From: [Lonnie Hartwig](#)
To: [Chace Pedersen](#)
Subject: Egan Short Platt Comment
Date: Monday, April 3, 2023 7:52:40 AM

Therefore, we object to the granting of this subdivision and want to see it declined.

EGAN SHORT PLAT

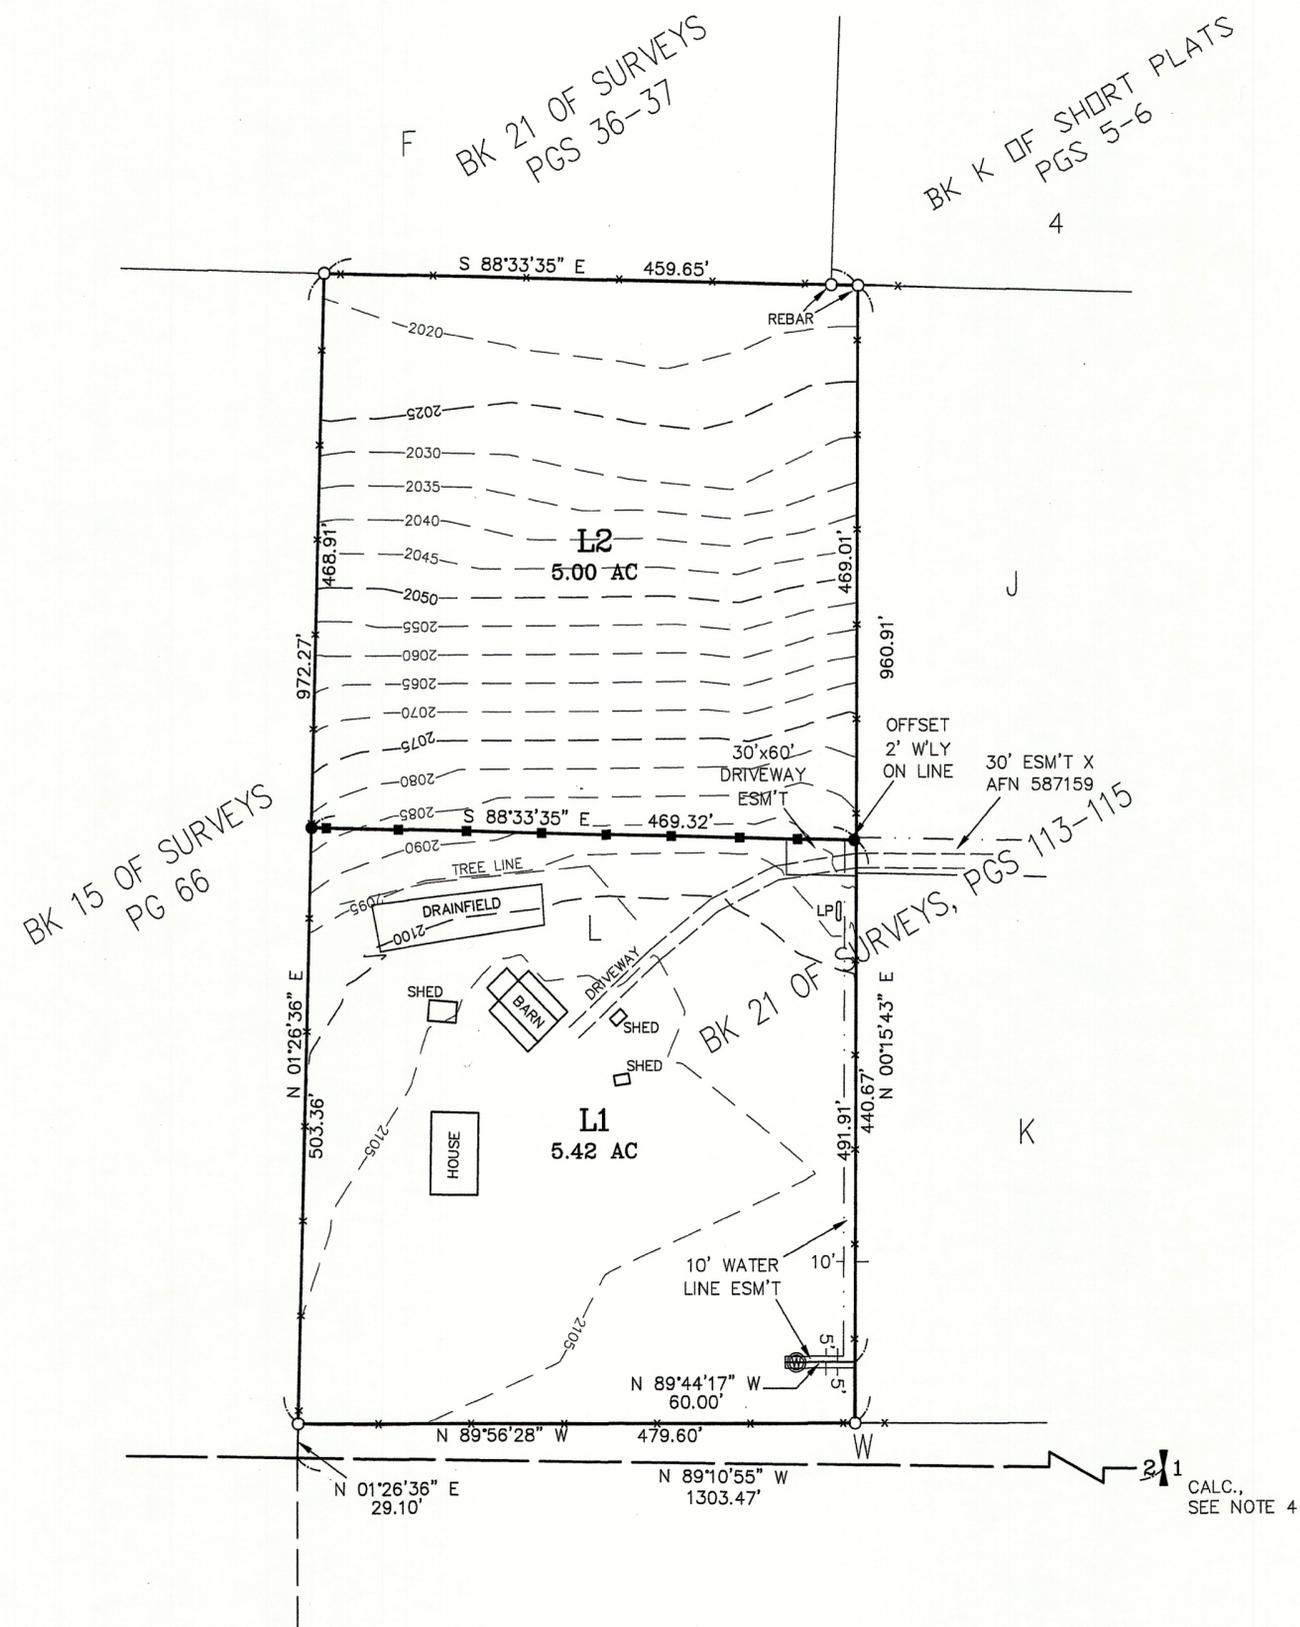
We own parcel 955117 on Iron Mountain Road. The easement road along the east edge of our property serves our property as well as the parcels further up the road. The road is narrow and has been difficult to maintain due to the slope and many years of traffic causing washboarding on most of the hill. The proposed subdivision would obviously increase traffic and dust on the road. Without substantial improvement this increased traffic will further degrade the road.

Furthermore, the road is not wide enough for two vehicles to pass one another. With more traffic, more problems will present themselves and safety will become an even bigger issue. When the snow gets deep the problems only increase due to the road becoming an even narrower track.
